Re: Case Number ABP-319843-24 - Proposed Development for a Facility Centre for Water based Activities Magherabeg Beach, Castlegregory, in the Townland of Magherabeg, Co. Kerry.

Subject: Response to Request for Further Information in relation to the effects of the environment of the proposed development.

TITLE: PROPOSED DRAINAGE LAYOUT

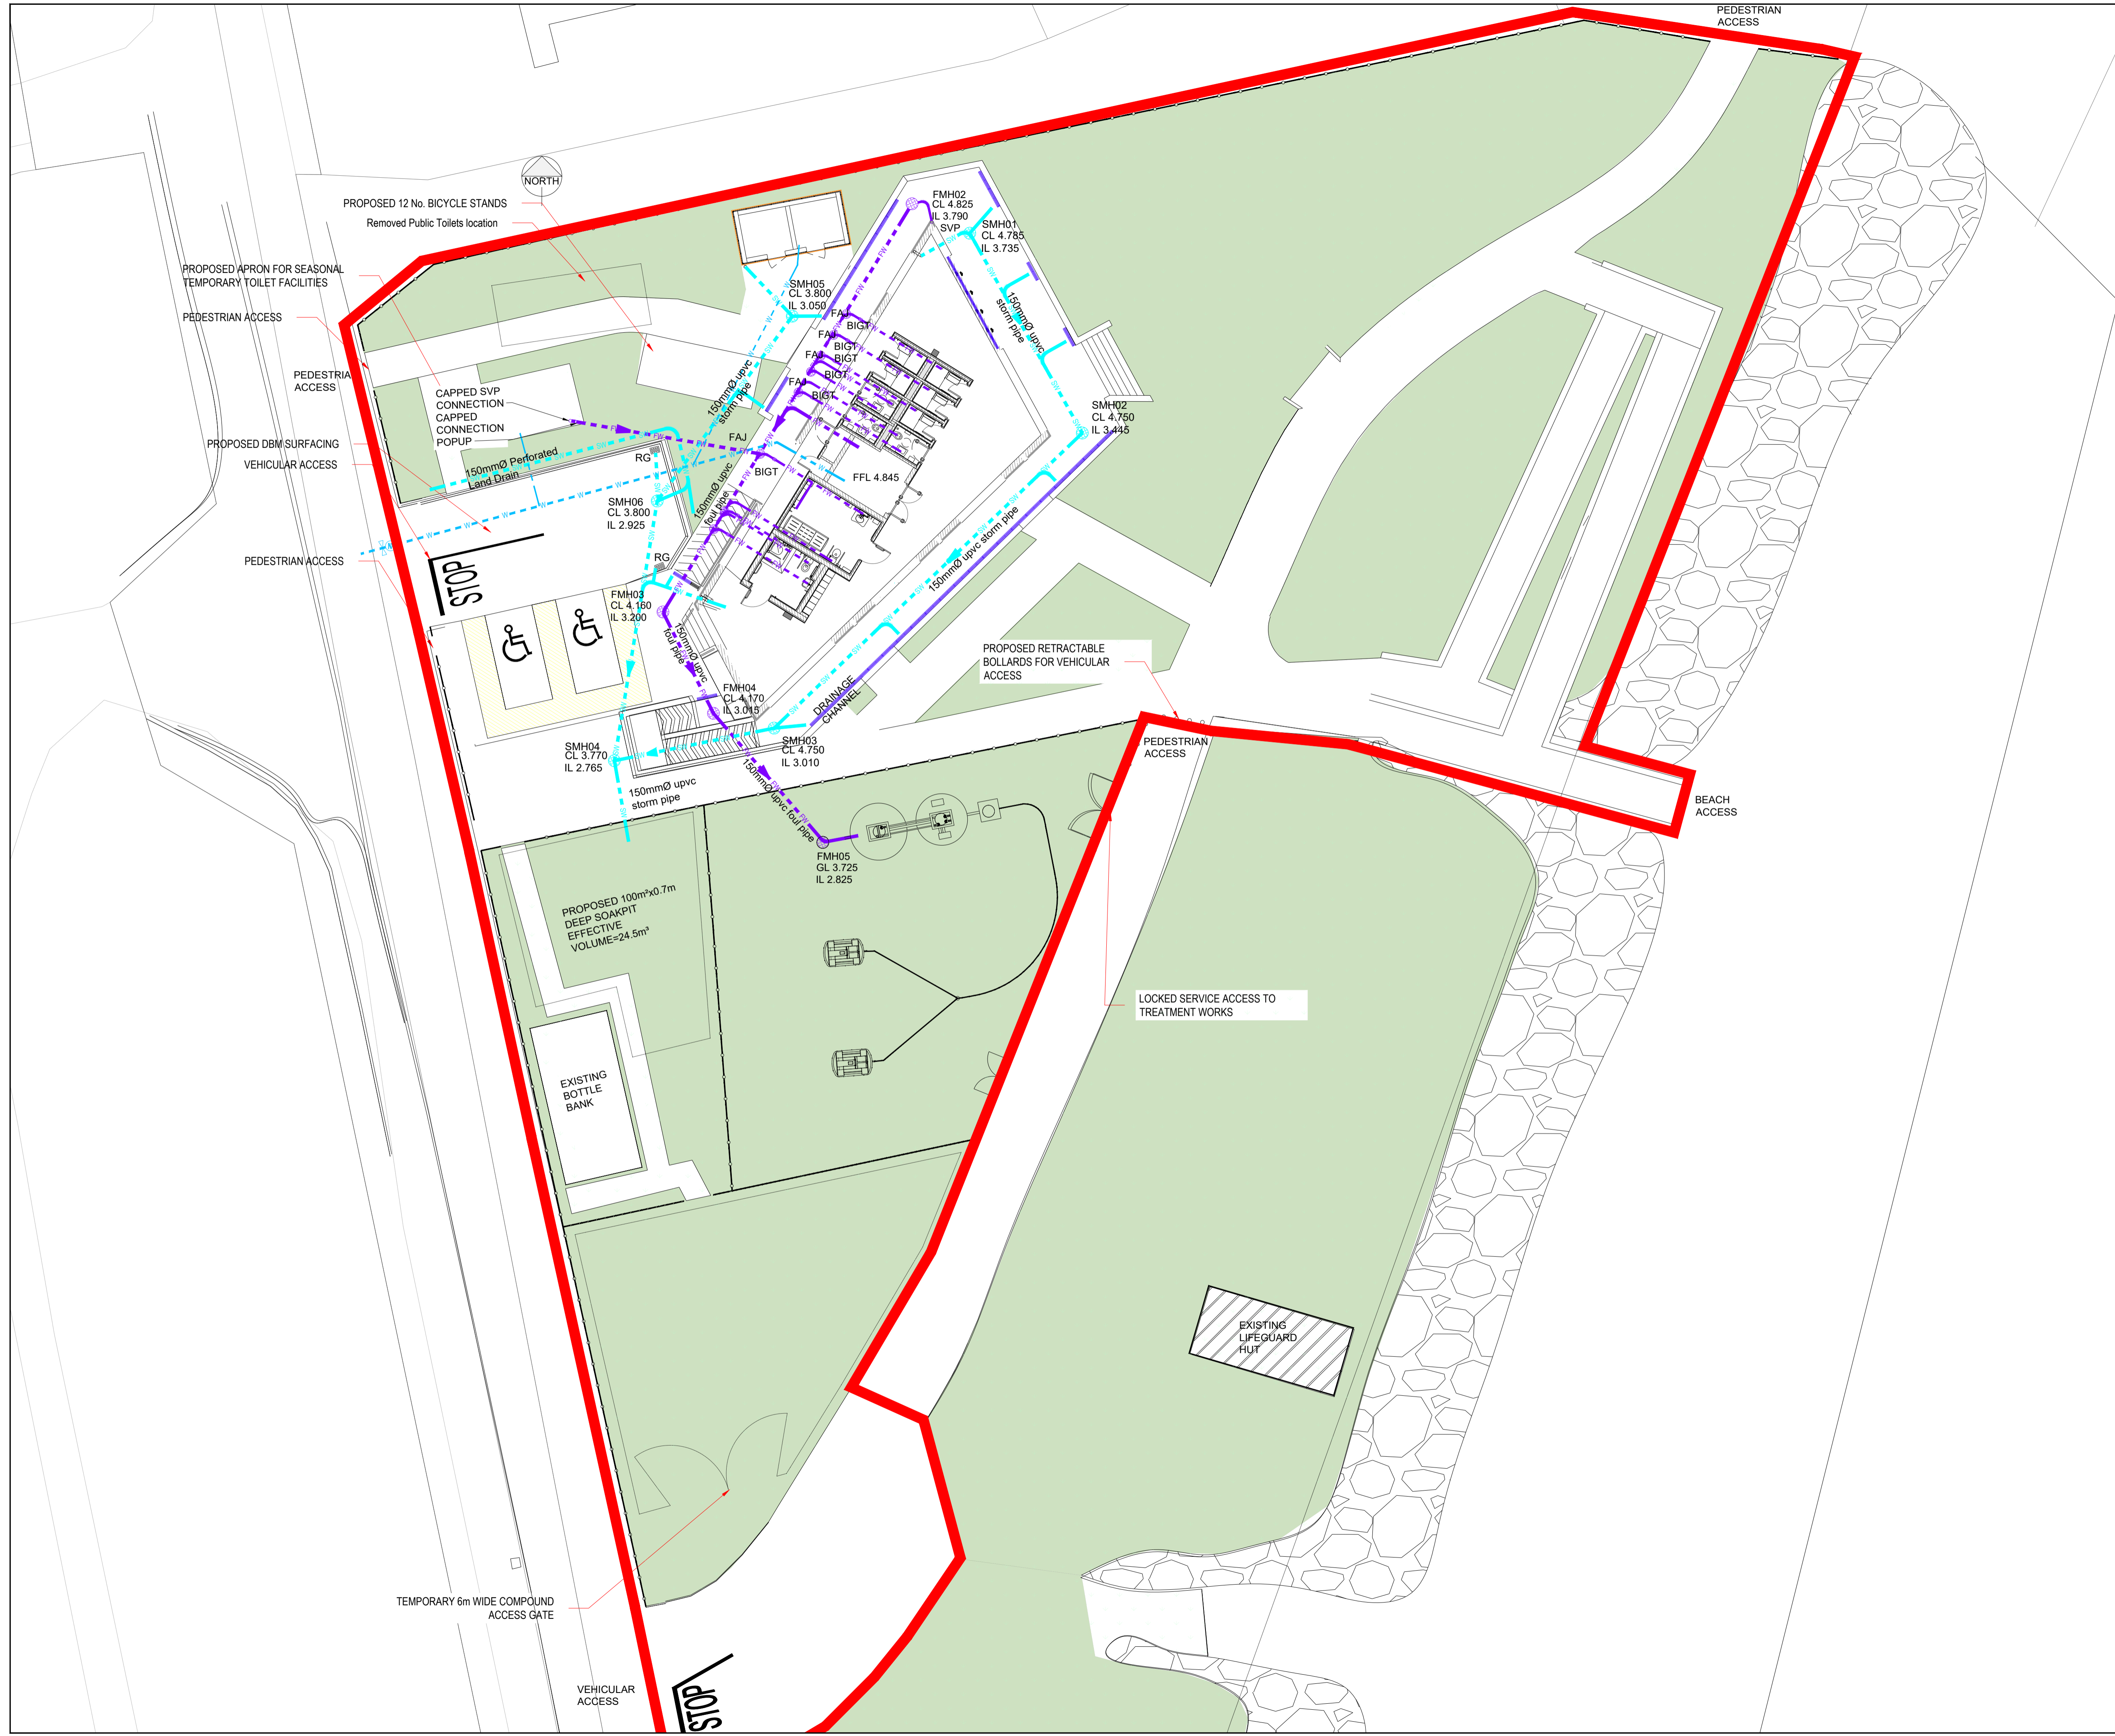
- iii. Identify each unlabelled structure/item shown on the submitted Proposed Water Services Drawing no, 23173-MWP-00-01-DR-C-0105 including items within the vicinity of the underground percolation area and those along the northeastern part of the site, in particular that which is to be connected to the proposed foul drain. The existing toilet block on site should be removed and the updated site layout plan should reflect this.

- iv. Correctly identify the area where the proposed underground percolation system is to be located, this location should also be reflected on Drawing no. 23173-MWP-00-01-DR-C-0105 and referred to in an updated NIS. In addition the NIS should be updated to include the most up to date version of drawing no. 23173-MWP-00-01-DR-C-0101.

- (iii) Updated **Drawing No 23173-MWP-00-01-DR-C-0105-P09 Proposed Drainage Layout** addresses unlabelled structure/item previously shown on the submitted Proposed Water Services Drawing no. 23173-MWP-00-01-DR-C-0105 including items within the vicinity of the underground percolation area and those along the northeastern part of the site, in particular that which is to be connected to the proposed foul drain. This drawing also reflects the previous existence of, and removal of the existing toilet block as well as new provision for similar and equal seasonal free-to-use facilities.

- (iv) The location of the proposed underground percolation system is shown in updated **Drawing No 23173-MWP-00-01-DR-C-0105-P09 Proposed Drainage Layout**. This information has also been included in the revised NIS. Refer to **Document No. 25609-6004 25609-ZZ-ZZZ-RP-MWP-EC-6005**.

TITLE:  
**PROPOSED TREATMENT SYSTEM SECTION**

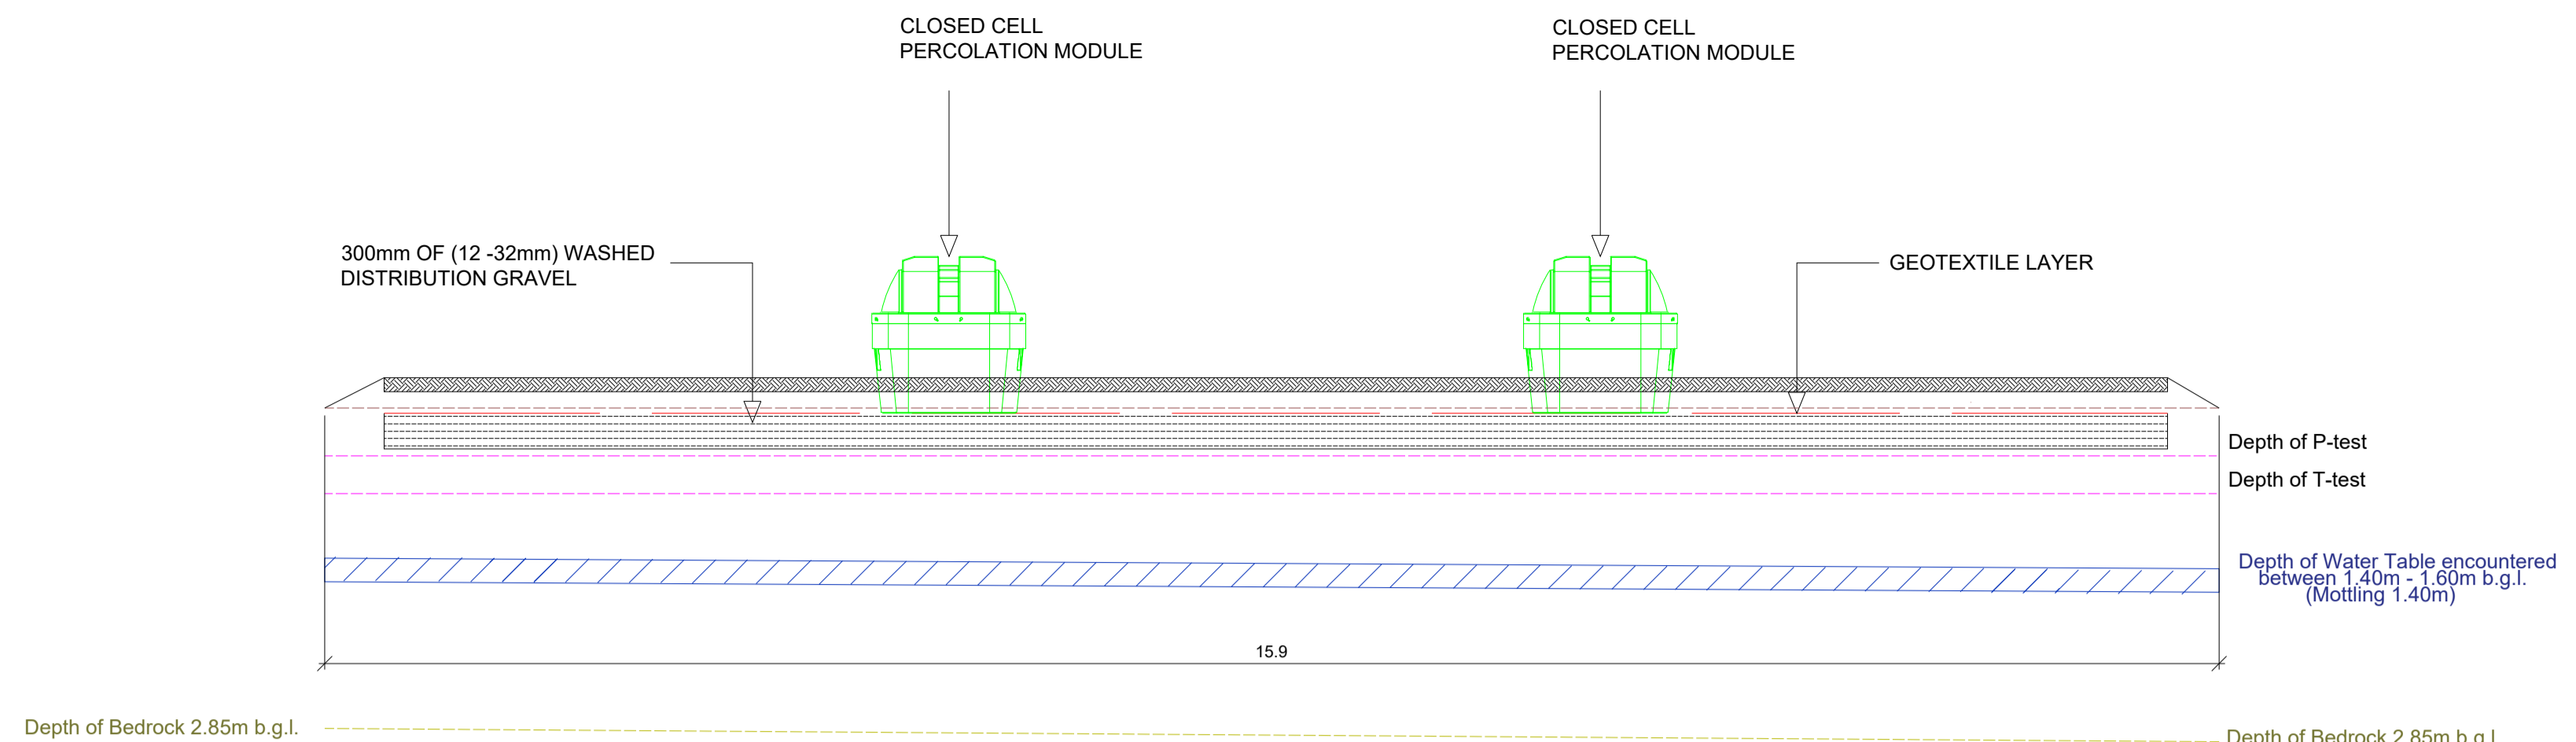
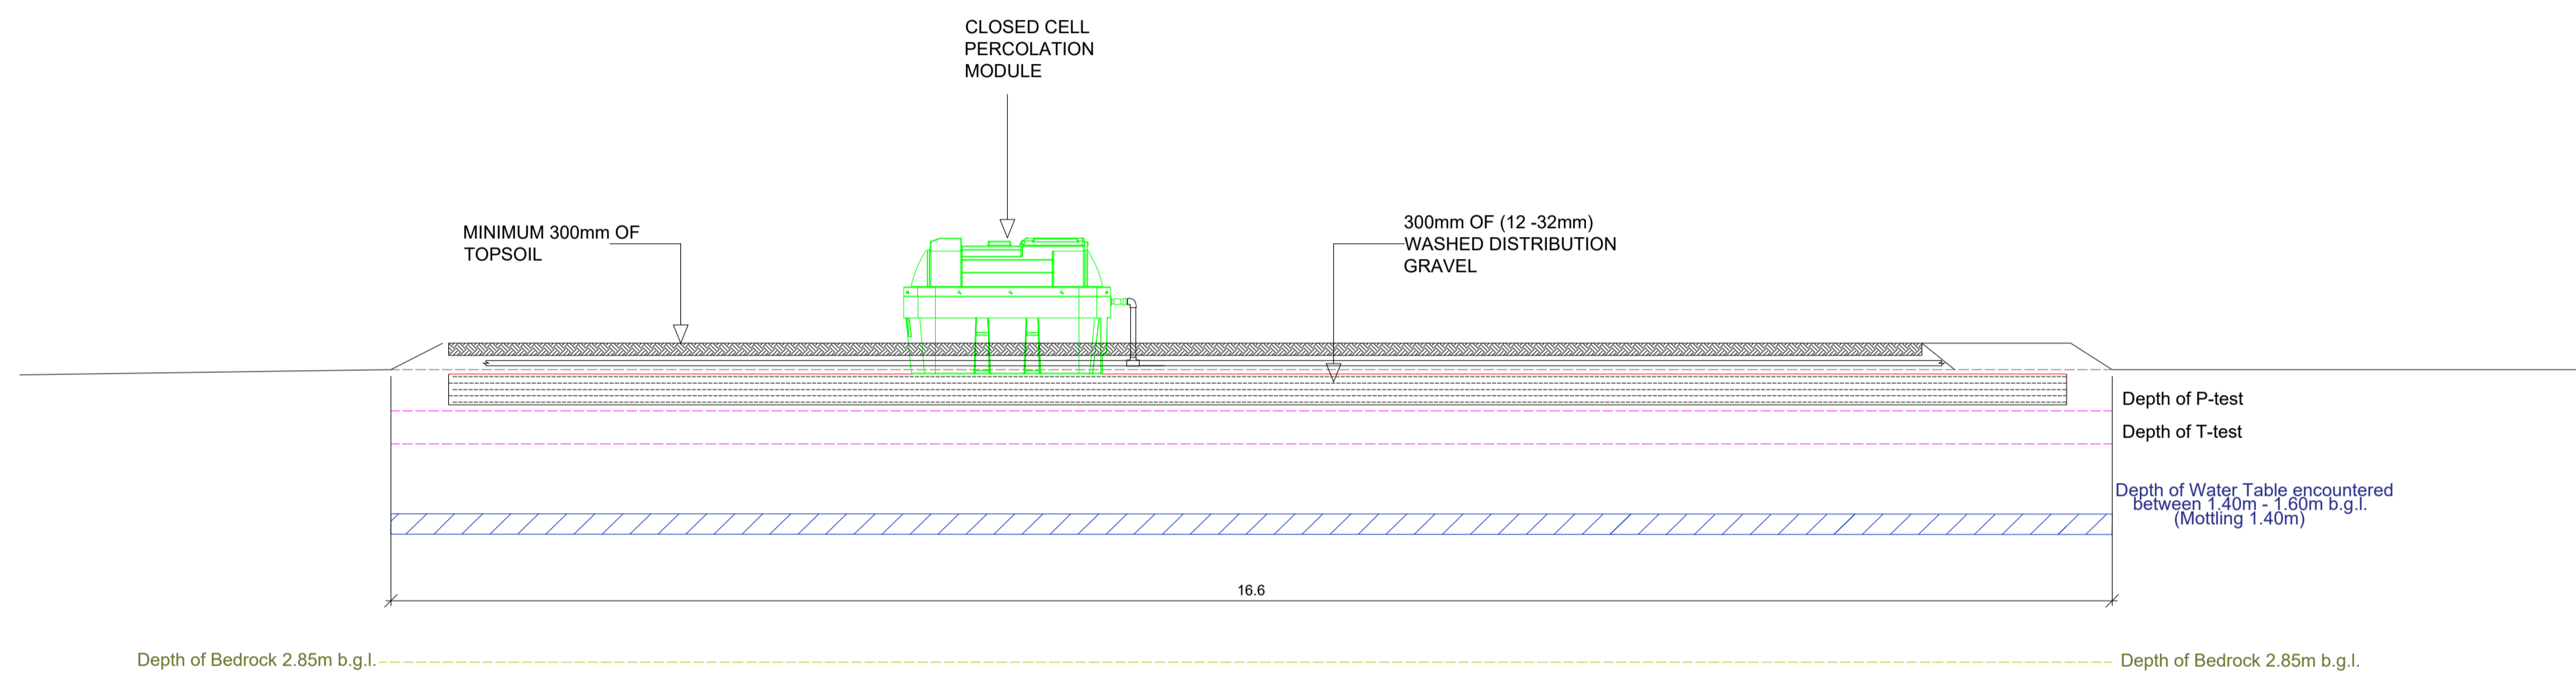
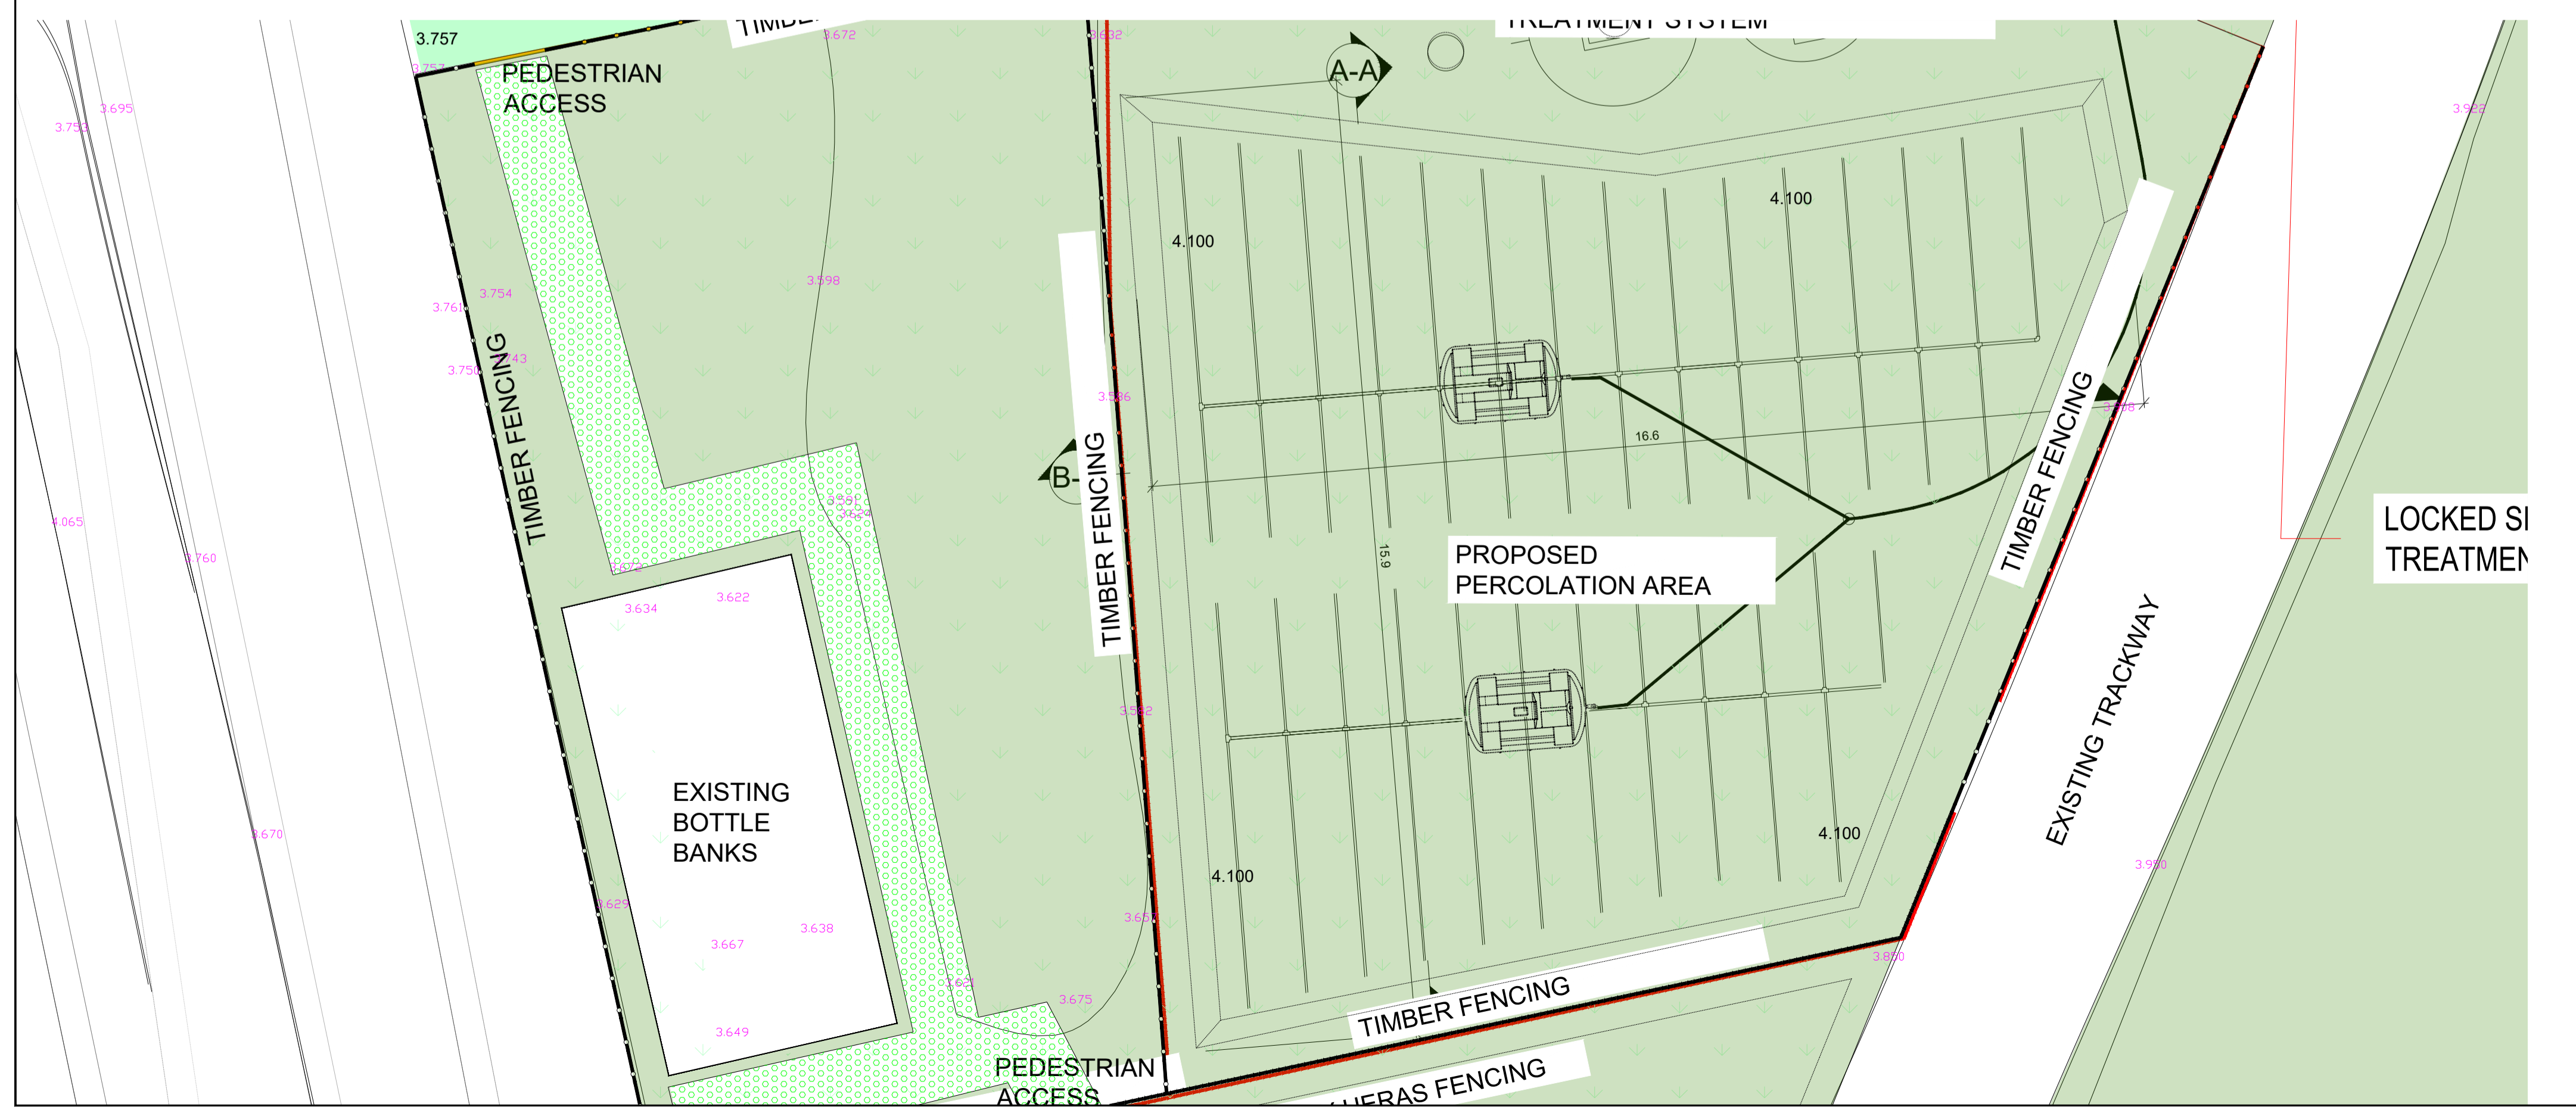
Ground Elevation levels are absent from the submitted site layout drawings and therefore it is not clear what the changing levels are and the differing levels between the site entrance and the disabled access ramp. Likewise with regard to the wastewater treatment plant, the relationship in level between the facility producing the Wastewater and the treatment facility receiving the wastewater is also not clear. While noted that the Wastewater Treatment System document does provide invert levels on the Cross Sections (23172 MWP 00 00 DR A 0420) on page 40/41, there is no way of cross referencing these with the actual ground levels.

- i. Details should be provided on the proposed quality of the discharge that the system can achieve and provide a summary of the key parameters and anticipated values.
- ii. Using the information determined under point i. above, an evaluation of the impact of treated wastewater treatment system on the receiving water should be undertaken. This assessment should be undertaken by a competent professional and should also include an examination of the proposal in terms of compliance with the objectives of the Water Framework Directive (WFD). Details and results of this assessment to be submitted.

- (i) MWP have reviewed and revised the Wastewater Treatment System Design. A detailed description of the proposed Wastewater Treatment System outlining updated design parameters and discharge quality is provided in MWP Document: **25609-MWP-ZZ-ZZ-RP-CE-6001-P01 Wastewater Treatment System Design Report**.

The revised Wastewater Treatment System also includes a raised percolation area which is designed in accordance with the EPA Code of Practice for Domestic Waste Water Treatment Systems 2021. This ensures that there will be no direct discharge to the beach or tide.
